KITTTITAS COUNTY COMMUNITY DEVELOPMENT SERVICES

Subject: Suncadia Ph 3. Div. 14 (LPF-18-00007) Final Plat – Staff Review and Request for Additional Information

Kittitas County Community Development Services (CDS) received your Suncadia Ph. 3 Div. 14 (LPF-18-00007) Final Plat submittal on September 27, 2018. Final plats must be processed and approved by BOCC within 30 days of the submittal date. Kittitas County staff have completed the review of your final plat submittal. As provided below, staff has the following comments, requirements, and/or revisions for your application that need to be addressed prior to final approval and signature of the final plat mylars:

DATE: 2018-09-26 JOB NO. 998-767-017-0100
DRAWN BY: C.A.F./R.F.G. SHEET 1 OF 5

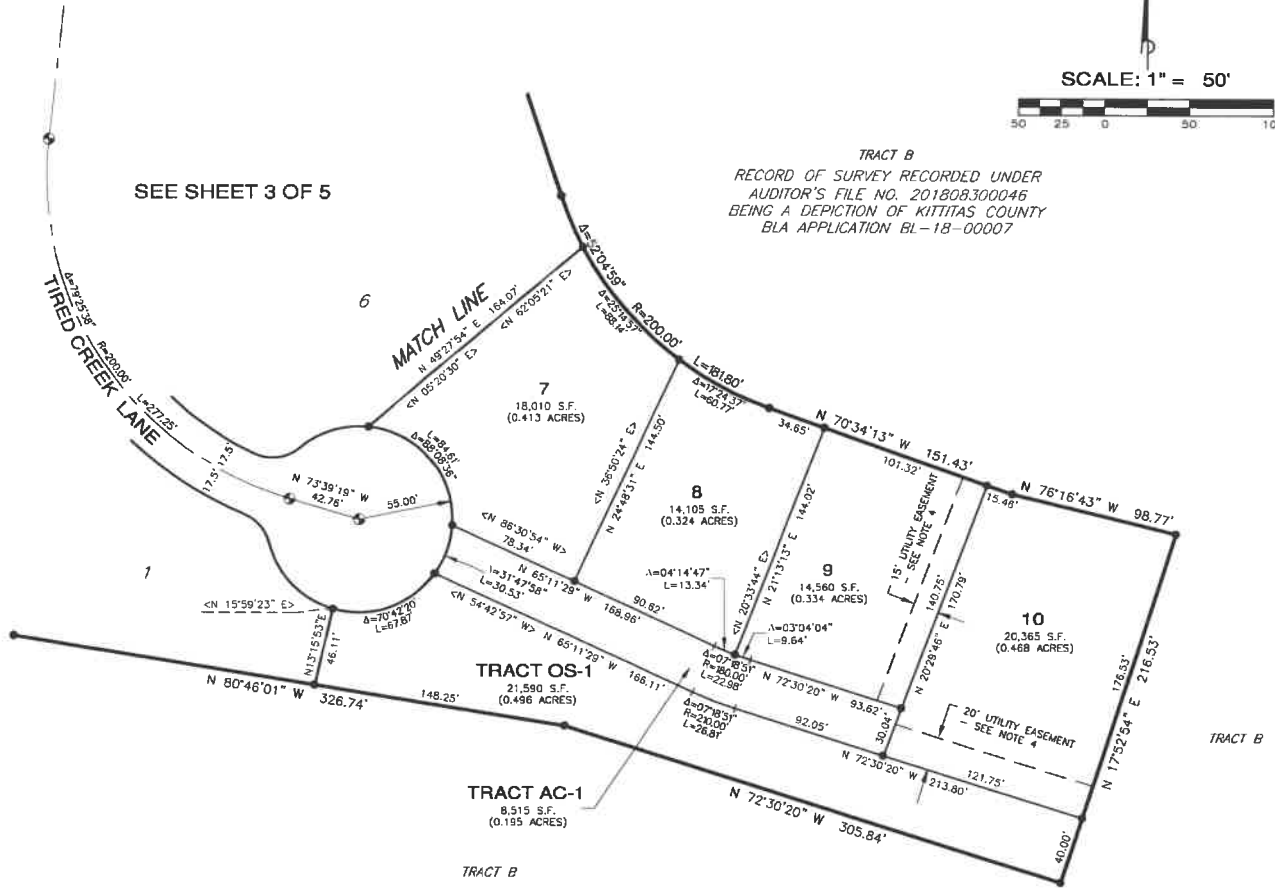
- **Required Changes**
 1. On sheet 1 the Recording Certificate is shown in two locations.
 2. Sheets 3 and 4 are missing the surveyor stamp.
 3. Please check the bearings and distances as shown on the access road North of Lots 3 and 4. If I retrace the access road from the N'most corner of Lot 3, I am unable to close on the NW corner of Lot 4.
